PLANNING APPLICATION CONSULTATION RESPONSE

Application Number:	3/2023/0812
Proposal:	Approval of details reserved by conditions 5 (surface water drainage), 6 (construction drainage plan), 7 (surface water operation and maintenance manual), 10 (construction method statement), 13 (travel plan), 19 (pedestrian link), 20 (bird and bat boxes and hedgehog features) and 24 (external materials) of planning permission 3/2023/0153.
Location:	Old Row Whalley Road Barrow BB7 9AZ

Lead Local Flood Authority Position

Status	INFORMATION
Drawing Title	Hydrobrake Detail

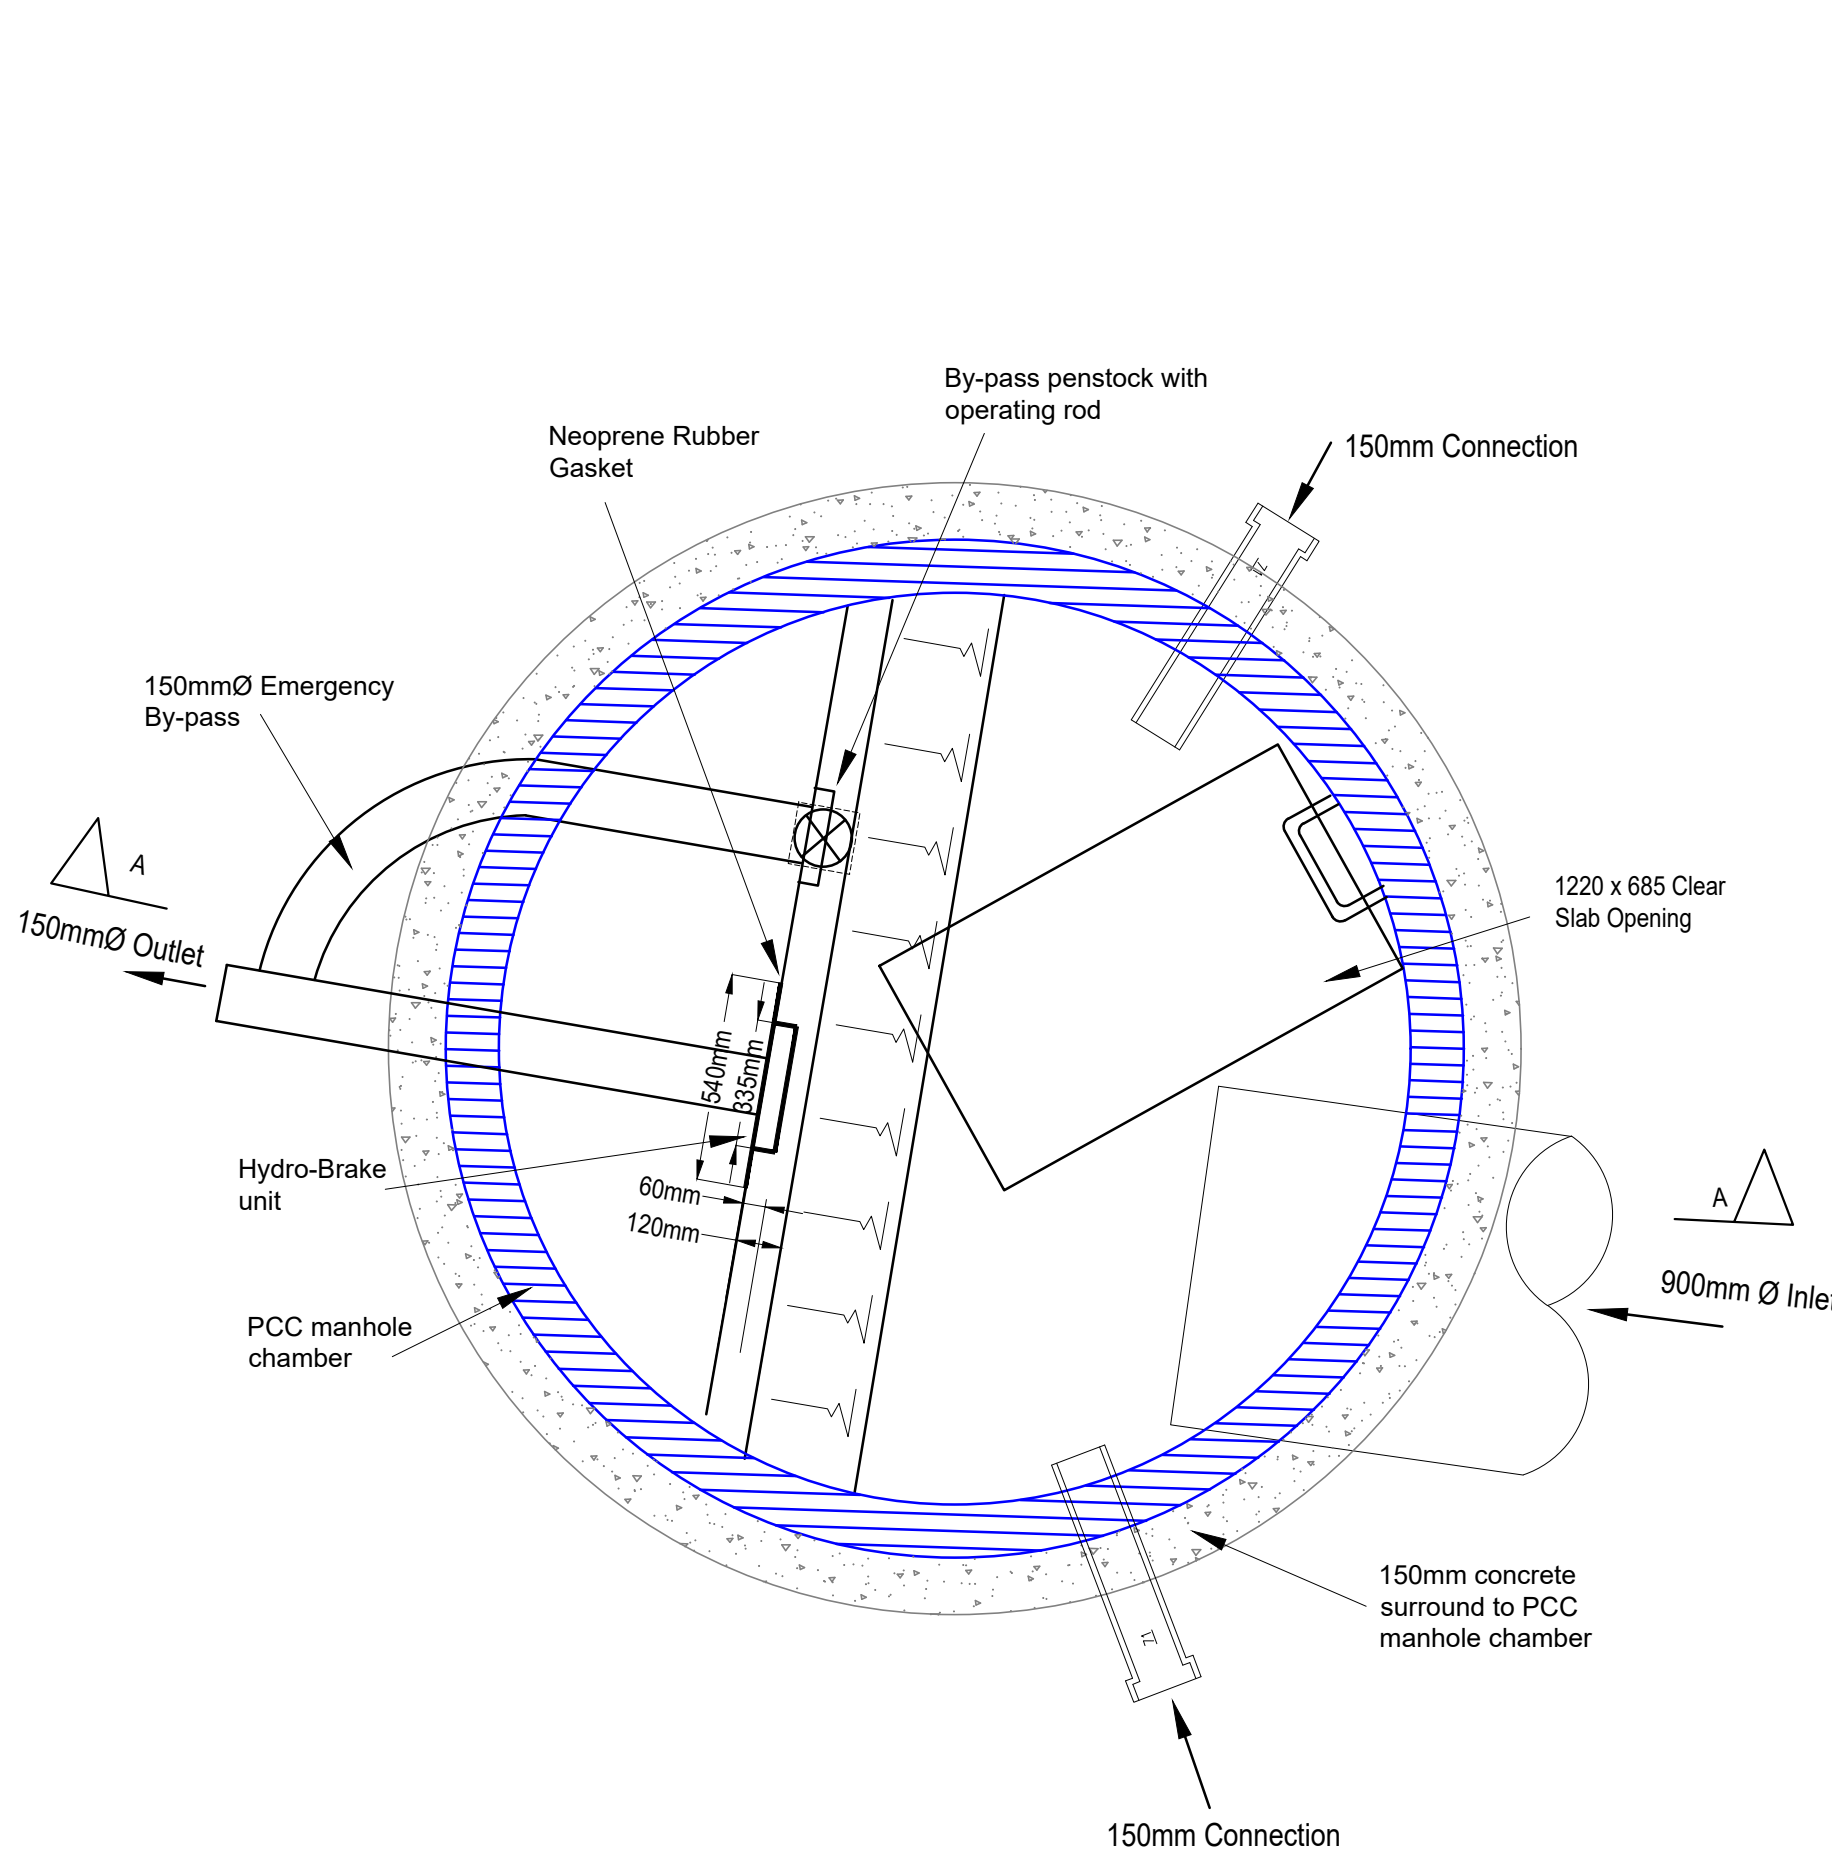
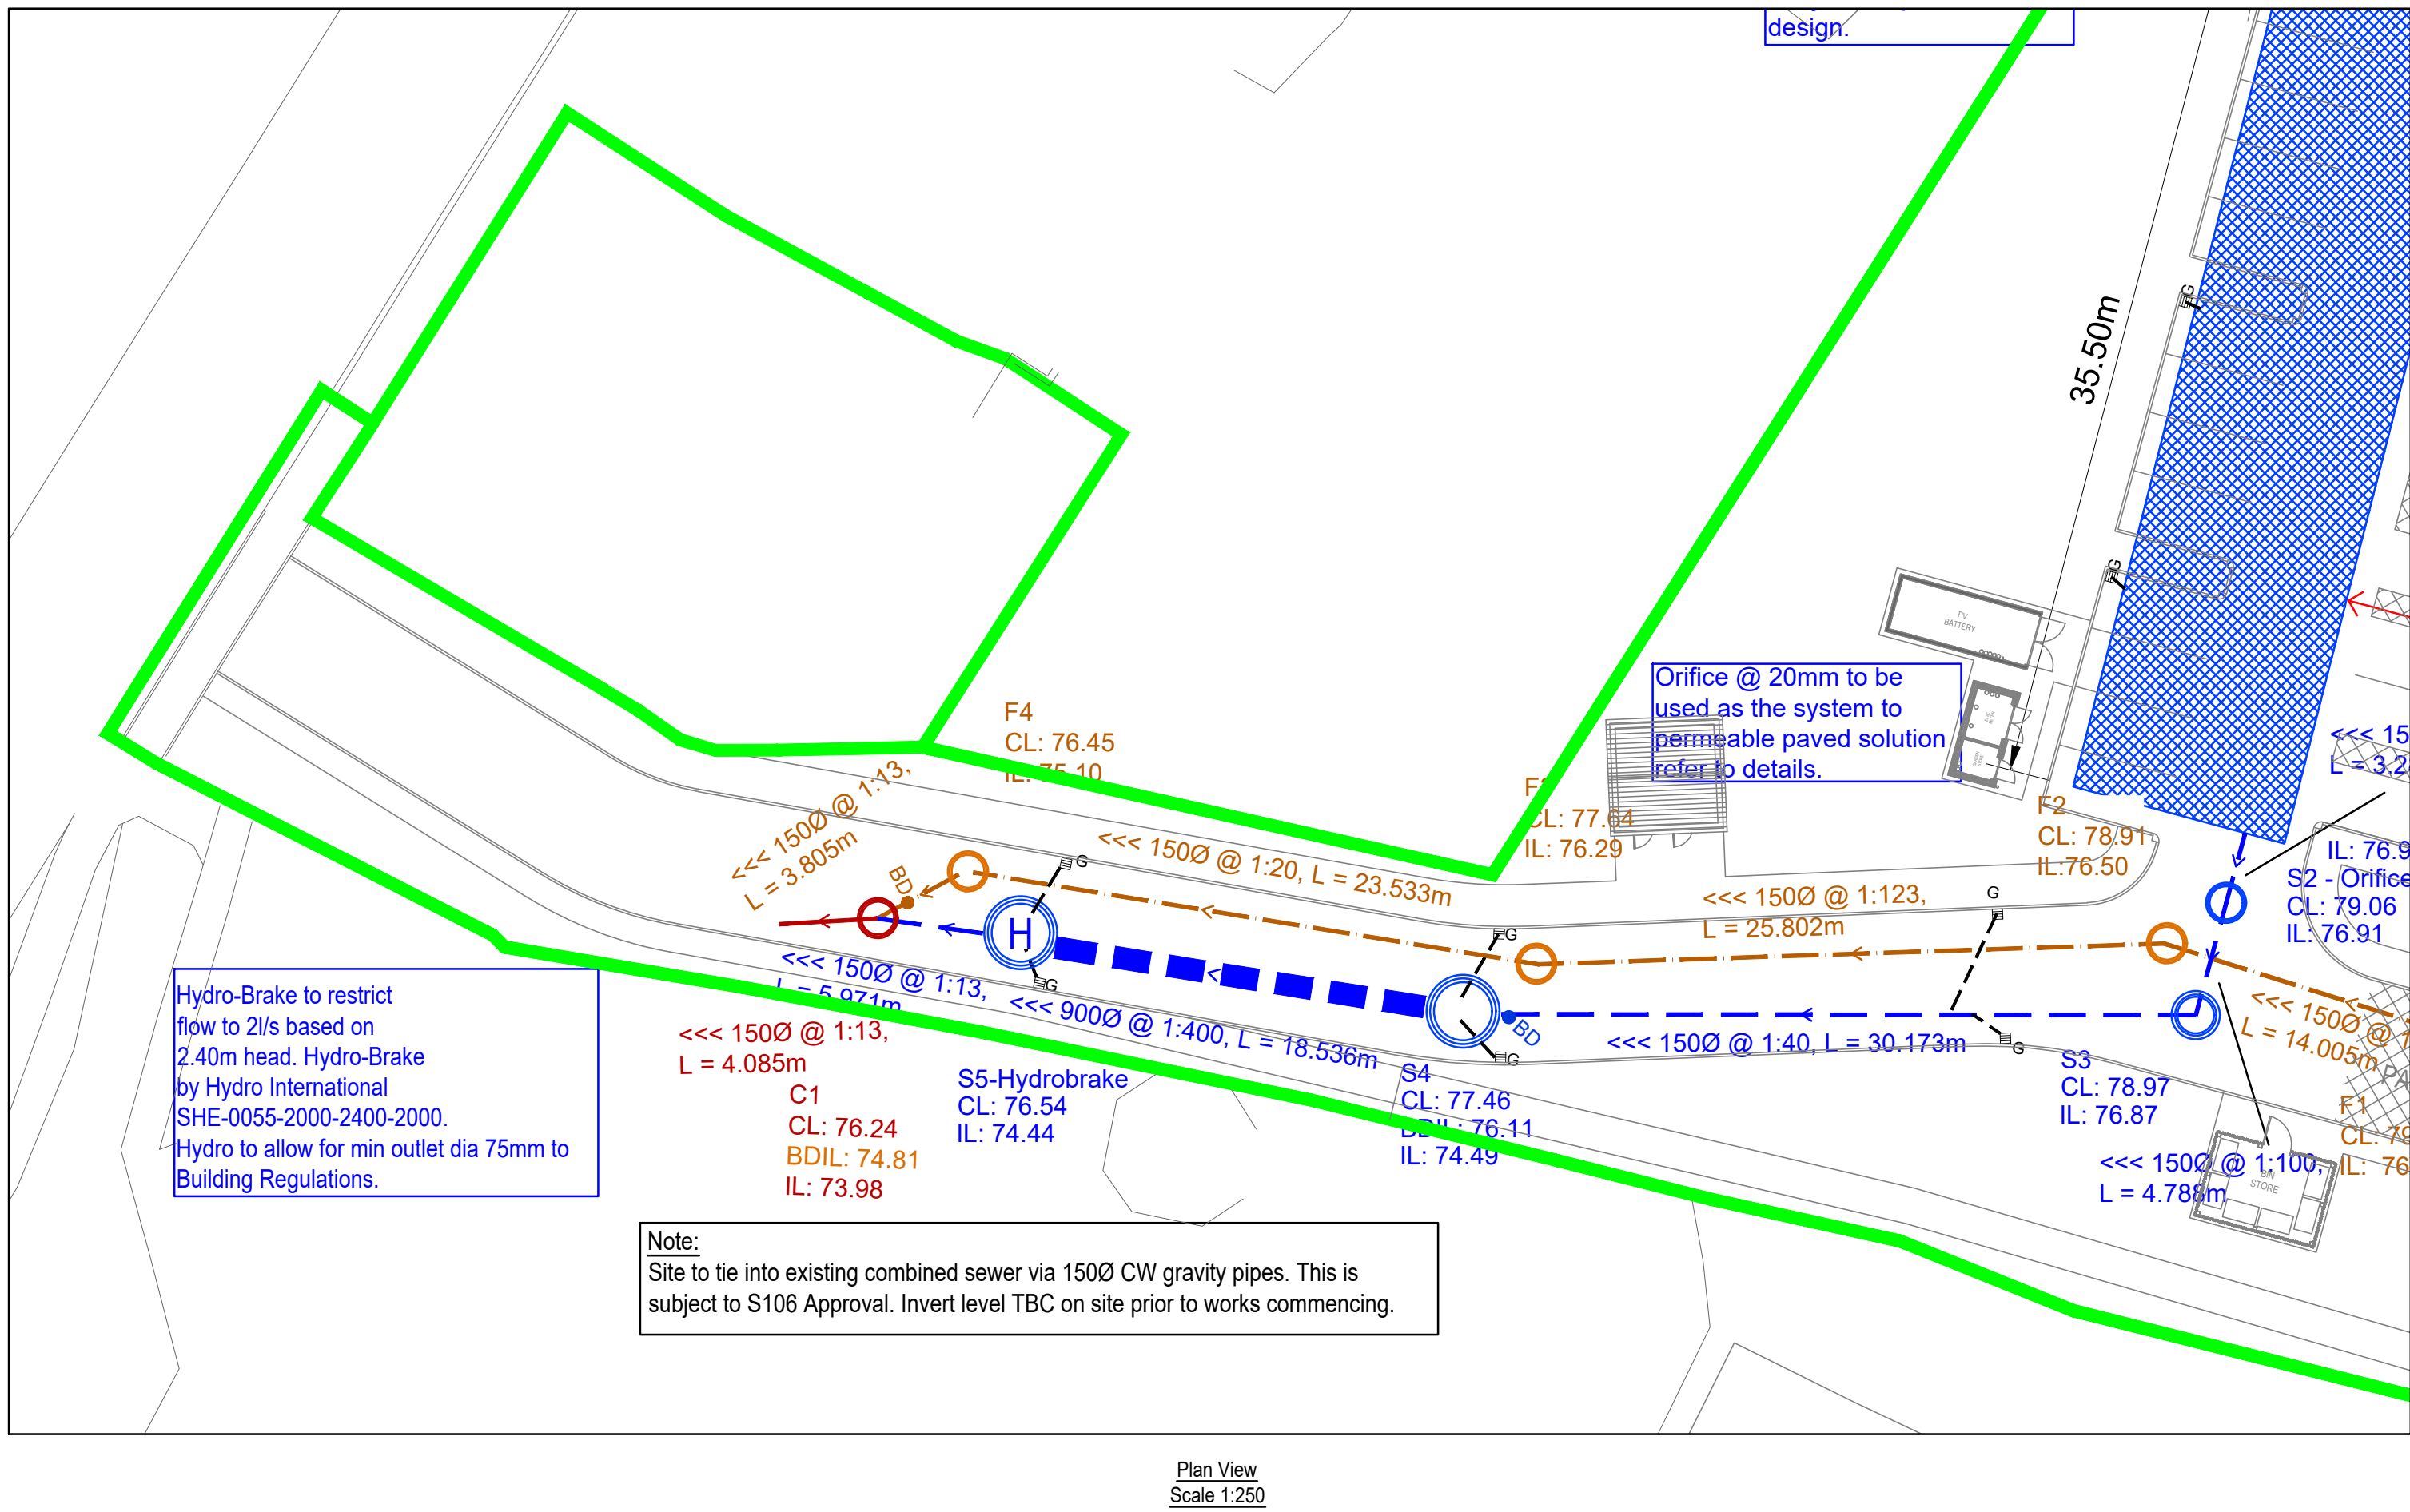
- The applicant has failed to provide evidence that a free-flowing outfall can be achieved. If this is not possible, evidence of a surcharged outfall applied to the sustainable drainage calculations will be required.
- The applicant has failed to provide evidence of an assessment of the site conditions to include site investigation and test results to confirm infiltrations rates and groundwater levels in accordance with BRE 365.
- The applicant has failed to provide evidence of an agreement in principle with the third party asset owner to connect to the off-site combined sewer.

The applicant should ensure that appropriate management and maintenance is provided, specifically in regard to the flow control device and its discharging at 2l/s.
